FIRE RISK MANAGEMENT, INC

Memo Report

Subject: Code Review and Life Safety Evaluation; ICW Building Located at 106/108 High St., Portland, ME

THIRD FLOOR PLAN

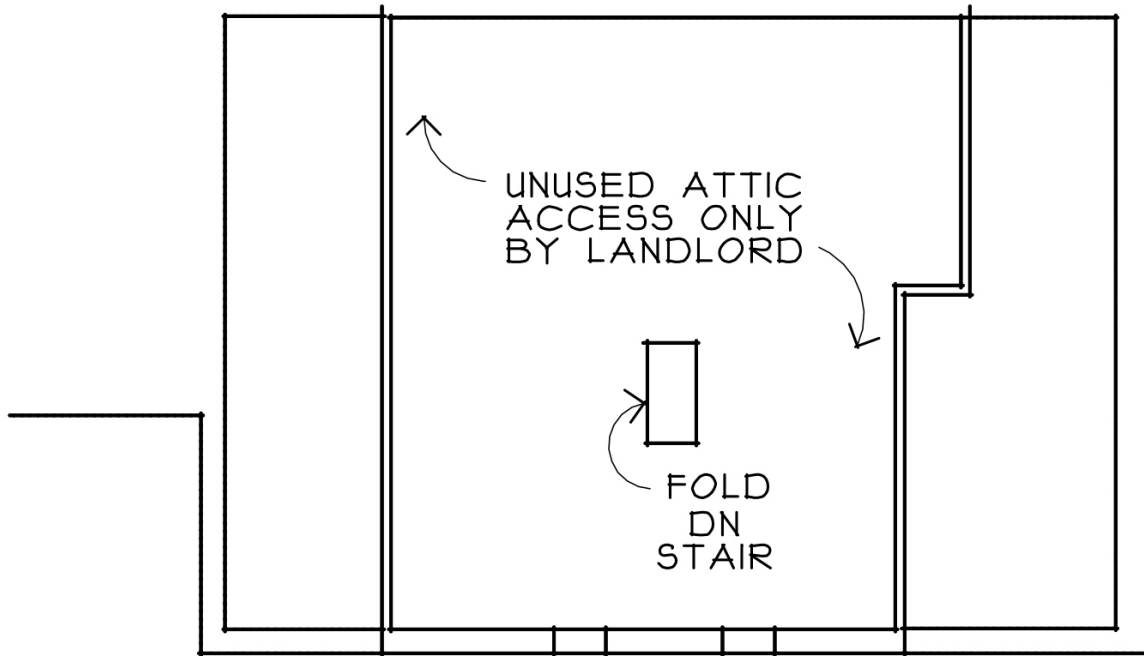
Based on the review performed of the building and the proposed design documents for the renovation activities associated with the 3rd floor alterations, this renovation would be classified as a “Level 2 Alteration” as outlined by the IEBC. The 3rd floor currently has only a single interior stair that provides an adequate means of egress from this space/floor.

Based on the size and use of the space (dance studio) to be located at the 3rd floor, an occupant load of 49 persons was developed, using an occupant load factor of 15 ft² per person, as outlined in NFPA 101 for this type of an assembly use. Based on this value, if this space were located on the same level as the other occupancies, it would have been allowed to have a single exit, as long as all other exit travel distance requirements were met; including “common path of travel” and “total travel distance.” For an assembly occupancy within a building that is fully protected by an automatic sprinkler system and that has an occupant load of less than 50, the maximum common path of travel distance would be 75 ft and the total travel distance to an exit would be 250 ft. For the 3rd floor space, the common path of travel distance would be less than 65 ft and the total travel distance to the ground floor exit would be less than 110 ft; both well within the limitations imposed by NFPA 101. The common path of travel distance for the 3rd floor is based on the fact that once occupants reach the top of the stairs at the 2nd floor level that lead to the 1st floor exit, they then have access to two separate exits; to continue down this stairway (Stairway 1) or move in the opposite direction, down the adjacent corridor to Stairway 2.

Based on the above travel distances, coupled with the fact that the building is to be fully protected with automatic fire sprinkler system, it is considered that if the proposed design is modified to provide the 3rd floor occupants with a fully enclosed stairway that is separated from the rest of the building by barriers having up to a 1-hour fire resistance rating, that this would provide an acceptable means of egress from the 3rd floor; even without the need for the exterior fire escape. However, to achieve an overall acceptable level of life safety and ensure that all building occupants are provided with adequate fire notification, the building should also be provided with a complete fire detection/alarm/notification system that meets the requirements of NFPA 72, the National Fire Alarm and Signaling Code[®]. The combination of having a fire-separated exit enclosure and early notification should provide more than sufficient protection for the 3rd floor level occupants of this building.

- The stair enclosure at the bottom of the stairway from the 3rd floor should consist of barriers, including the doorway, that have at least a 1-hour (60 minute) fire resistance rating. Even though the estimated occupant load for the 3rd floor is less than 50, the door of this enclosure should still be designed to swing in the direction of egress.

- The corridor adjacent to stairway 1 at the 2nd floor level needs to be isolated from the rest of the building by barriers having a 1-hour fire resistance rating since this corridor is to become part of the new stair enclosure for the 3rd floor occupants. This can be accomplished by the addition of a new fire-rated barrier at that isolates the corridor from the two doors that currently provide access to the business occupancy (artist studio) and bathroom. This space can still be accessed by the doorway from the adjacent corridor. A new fire-rated door is to be installed in the opening that separates stairway 1 from the adjacent corridor to the south that leads to stairway 2. The shaded area shown in the attached sketch (Sketch 1) represents the new “enclosed” area that will be isolated from the rest of the second floor area; thereby providing 3rd floor occupants a means of egress that is completely separated from the rest of the building, from the point that they leave the 3rd floor level to the point they exit the building. The “red” lines shown on this sketch indicate where fire-rated doors and walls must be provided.
